MECKLENBURG COUNTY
Park and Recreation Department

MEMORANDUM

RE: Rezoning Petition # 2008-082 (PID #s 083-021-01 and 083-031-15)

ILLUSTRATIVE SITE PLAN
 PETITION NO. 2008-082

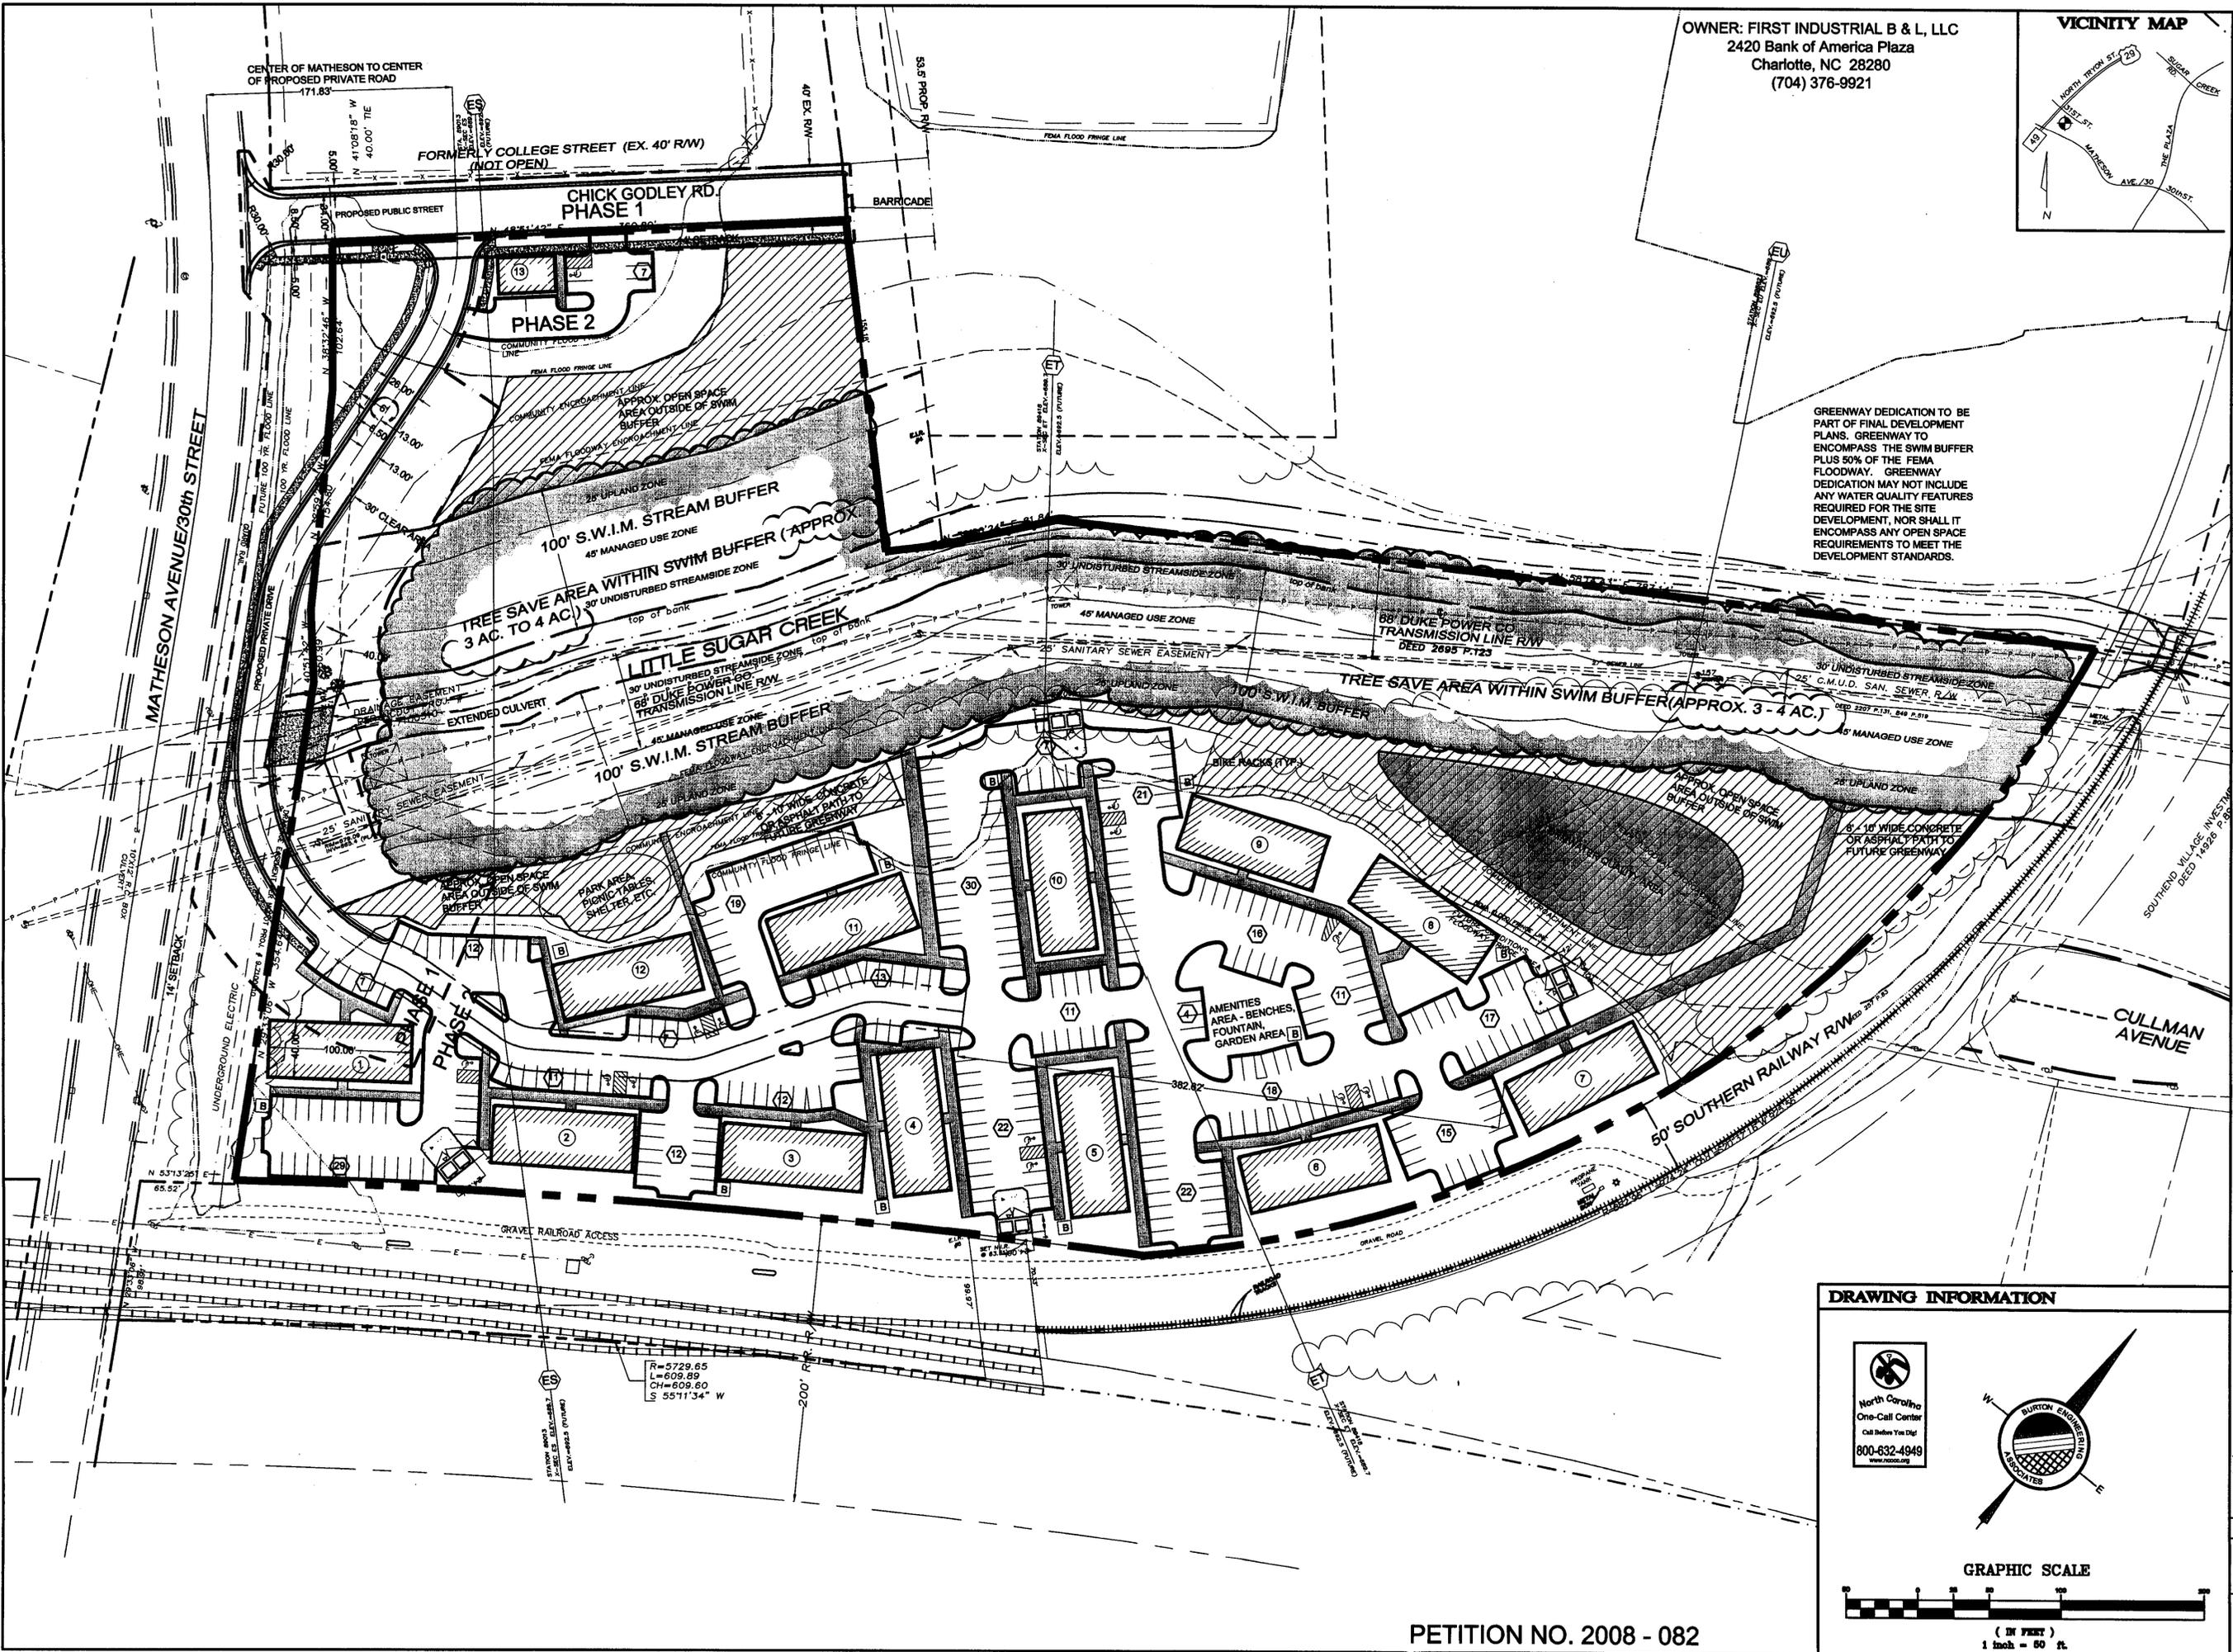
MCPR is satisfied with the dedication of the SWIM buffer and 50% of the FEMA floodway as described on Sheet 3 of the revised plans dated 9/23/08.

MCPR encourages the developer to continue seeking a pedestrian connection to Cullman Ave. following the existing gravel access road. This connection would allow residents access to possible future park amenities along Cullman Ave.
